**Response to Planning application from Hertfordshire County Council (T and CP GDP Order 2015)**

**District ref:** 6/2019/2313/FULL

Erection of six dwellings following demolition of existing buildings

Drawing Title
PROPOSED SITE PLAN

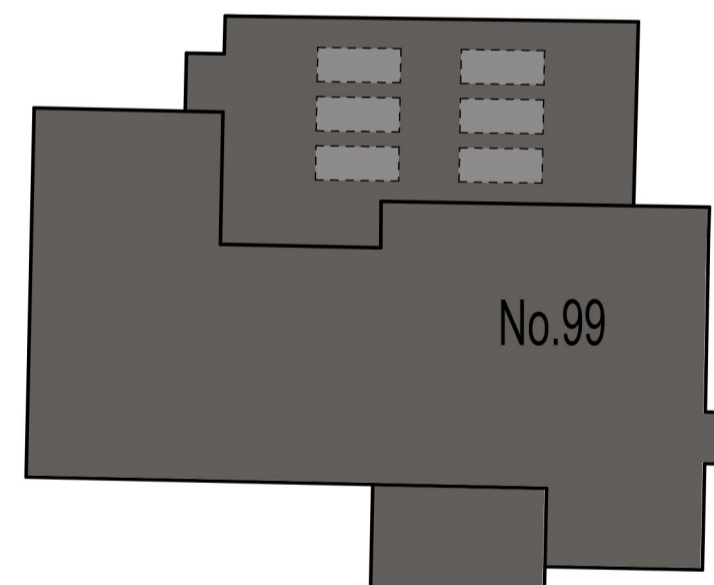
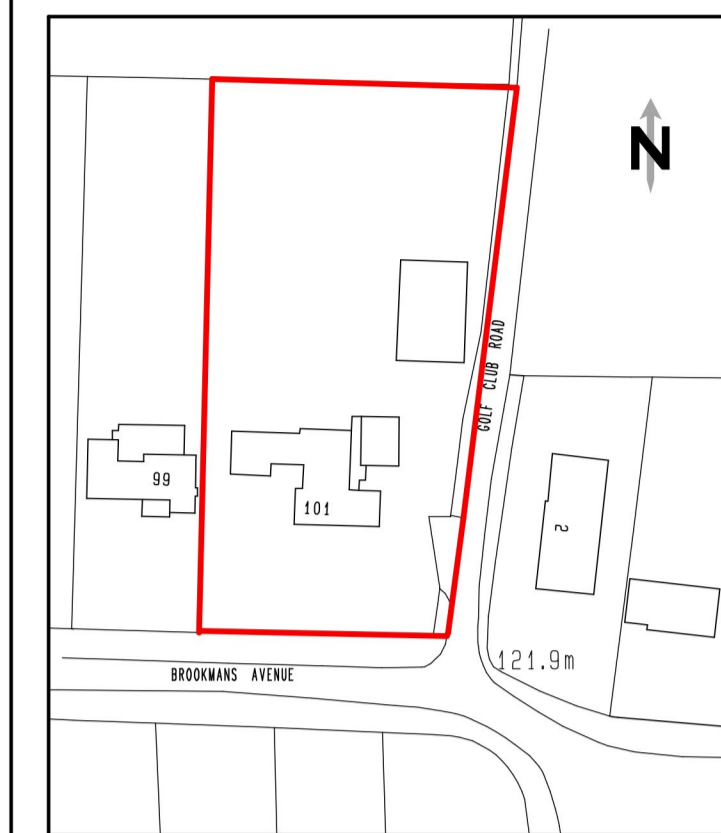
Con1) Concurrent with the use of the accesses on Golf Club Road, visibility splays of 2.4m x 33m shall be provided and permanently maintained in each direction within which there shall be no obstruction to visibility between 600mm and 2m above the carriageway level. Reason: To ensure construction of a satisfactory development and in the interests of highway safety in accordance with Policy 5 of Hertfordshire's Local Transport Plan (adopted 2018). Con2) Prior to the first occupation of the development hereby permitted the vehicular access shall be provided and thereafter retained at the position shown on the approved plan drawing number 485018-4 in accordance with the highway specification. Arrangement shall be made for surface water drainage to be intercepted and disposed of separately so that it does not discharge from or onto the highway carriageway. Reason: To ensure satisfactory access into the site and avoid carriage of extraneous material or surface water from or onto the highway in accordance with Policy 5 of Hertfordshire's Local Transport Plan (adopted 2018). Con3) Prior to the first occupation of the development hereby permitted vehicular and pedestrian access to and egress from the adjoining highway shall be limited to the accesses shown on drawing number 485018-4 only. Any other access or egress shall be permanently closed, and the highway verge shall be reinstated in accordance with a detailed scheme to be agreed with the Local Planning Authority, concurrently with the bringing into use of the new access. Reason: To ensure construction of a satisfactory development and in the interests of highway safety and amenity in accordance with Policies 5 and 7 of Hertfordshire's Local Transport Plan (adopted 2018).

I have included a condition that visibility splays of 2.4m x 43m should be provided to provide adequate visibility between the accesses for both vehicles and pedestrians using Golf Club Road. This will require the removal of some of the existing vegetation. The two proposed crossovers will need to be built in accordance with the Highway Authority's specification. The proposals include 3 parking spaces per dwelling indicated on Drwg 485018-4 is 4.8 x 2.4 wide with the required 6m clearance which is the recommended dimensions in Manual for Streets 8.3.58 and 8.3.51. The proposed second crossover is not subject to the Highway Authority specification. The Highway Authority are limited in the extent to which it is able to comment, noting that Brookmans Avenue is a privately maintained road, and therefore beyond the authority of the Highway Authority who are responsible for all roads / footways / verges etc. that are considered maintainable at public expense (the public highway). However, the local planning authority may wish to take note of specifications applied to Highway Authority roads for the proposed gates. We advise gates should be hung to open inwards, set back, and thereafter retained a minimum distance 5.5 metres from the edge of the highway. This would provide a safety measure as it gives space for vehicles to draw off the carriageway safely. Hertfordshire County Council as Highway Authority considers the proposals would not have an unreasonable impact on the safety and operation of the adjoining highways. Therefore; the Highway Authority would not wish to restrict the grant of planning permission subject to the inclusion of the above condition and informatives.
